EL PASO COUNTY PARKS DEPARTMENT | PARK PLANNING DIVISION

August 18, 2026

Subject: Mayberry Phase 2 PUDSP (PUDSP3251)

POSITIVE PLACE (FORMERLY MAYBERRY DRIVE) TYPICAL BOULEVARD SECTION F-F
90' R.O.W. 6" VERTICAL CURB
AMENDED TO MAYBERRY PHASE 1 PUD
DESIGN SPEED: 30 MPH
(URBAN RESIDENTIAL COLLECTOR)
SCALE: 1" = 5'

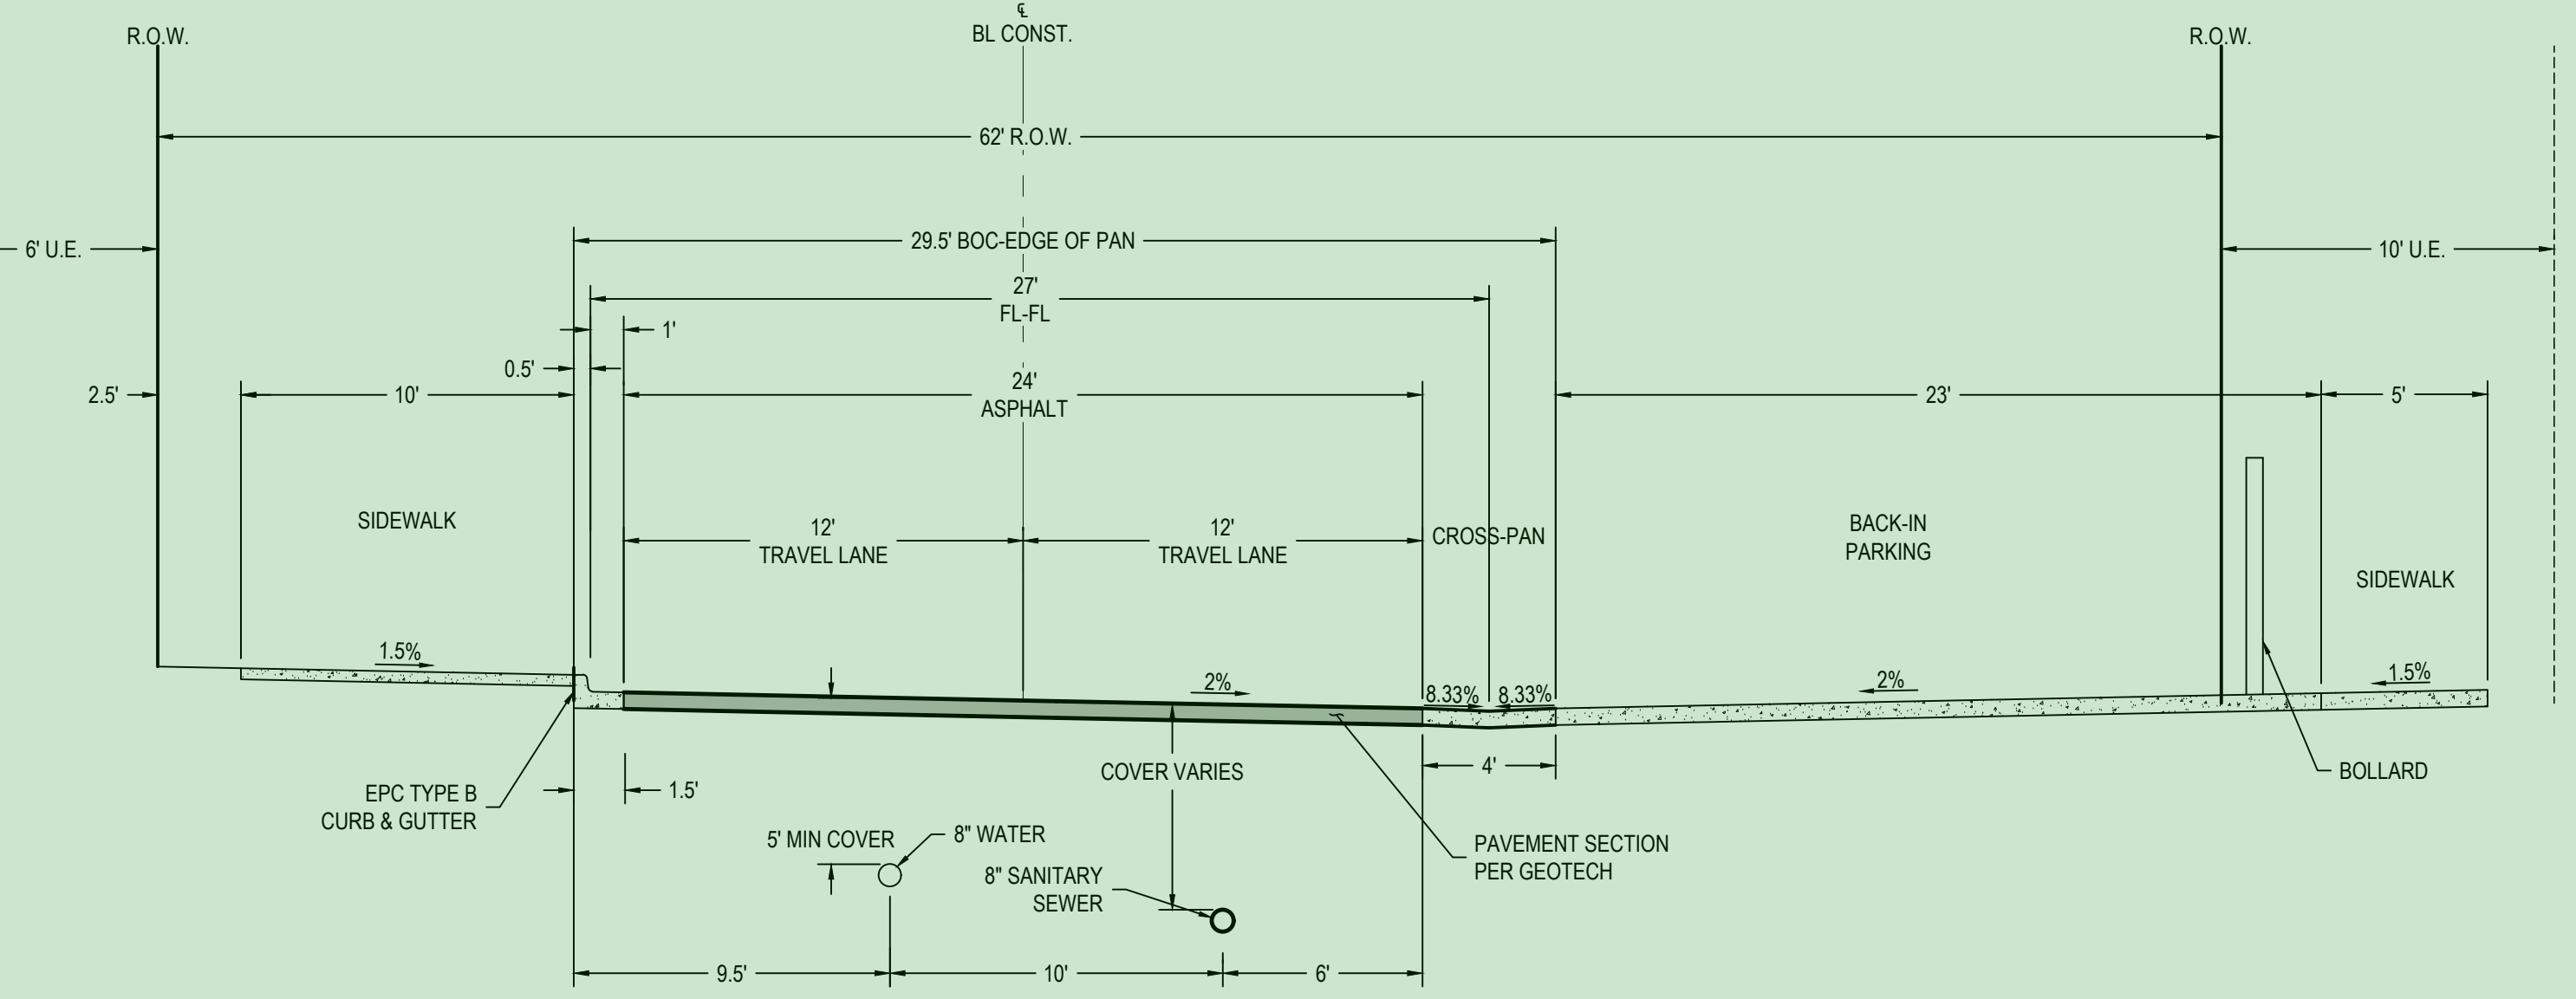
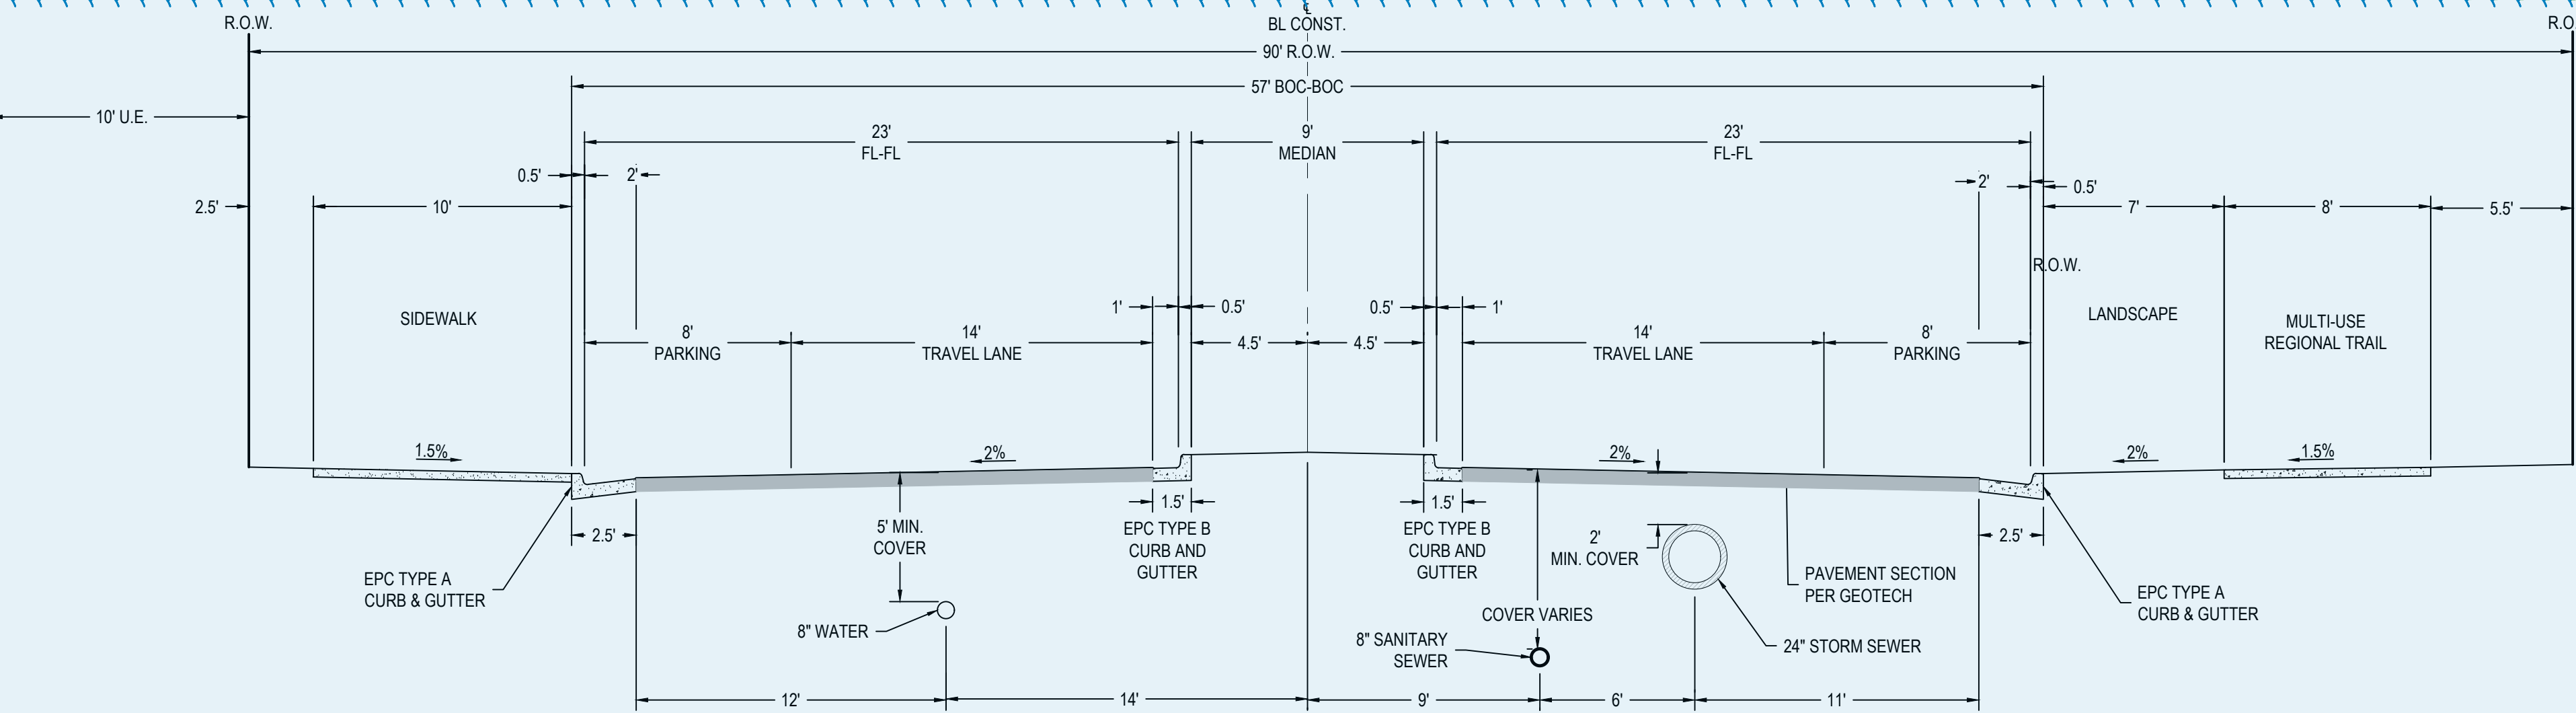
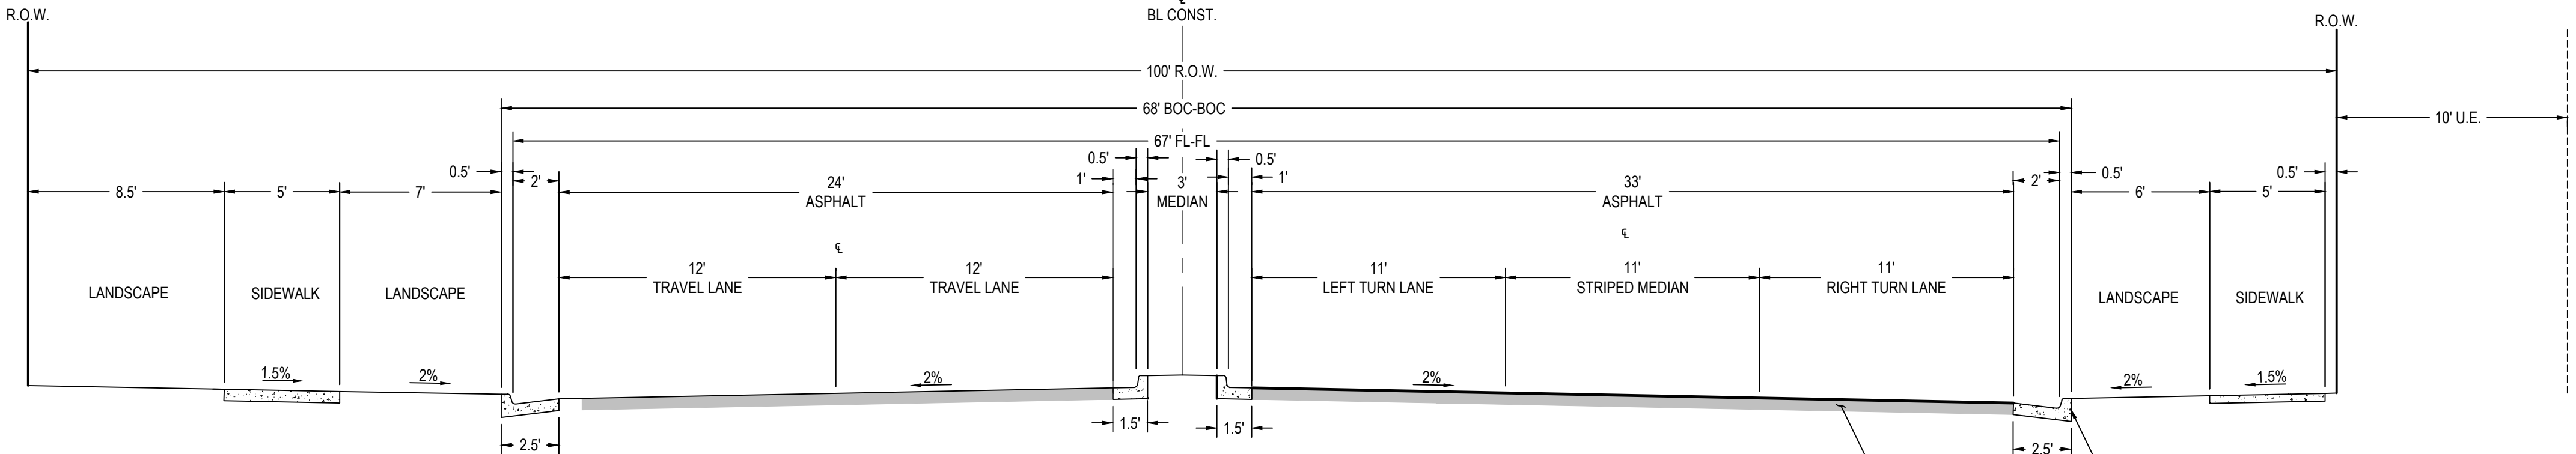
Staff also found that the Highway 94 Regional Trail is not correctly identified on the submitted plans. The proposed 8- to 10-foot-wide concrete sidewalks along Mayberry Drive and Positive Place are intended to function as the relocated El Paso County Highway 94 Regional Trail but are not labeled accordingly. The plans should be updated to clearly identify these facilities as the El Paso County Highway 94 Regional Trail. Additionally, corresponding notes should be added to the Preliminary Plan documenting the approved trail realignment and reflecting the coordination that has occurred between the applicant and El Paso County Parks staff.

The Park Advisory Board endorses the following El Paso County Parks Department comments, recommendations, and requirements as they relate to Mayberry Phase 2 PUDSP : (1) Recommend that the applicant designate and provide to El Paso County 8- foot wide sidewalks within the Right of way along the southern side of Positive Place for the Highway 94 Regional Trail, (2) the sidewalks shall allow for public access, as well as construction and maintenance by El Paso County of the Highway 94 Primary Regional Trail, (3) the sidewalks that are now the new configuration of the Highway 94 trail shall be shown on this preliminary plan and future final plats and shall be dedicated to El Paso County on the forthcoming final plat(s), (4) the Highway 94 Regional Trail shall be constructed of concrete and be min 8-ft wide in place of the standard sidewalk, (5) Regional parks fees in the amount of \$49,490, and urban park purposes in the amount of \$29,694 shall be required at the time of the recording of the forthcoming final plat(s), (6) an Urban Park Lands Agreement may be an acceptable alternative to urban park fees provided the agreements are approved by the County and executed prior to recording the forthcoming final plat(s).
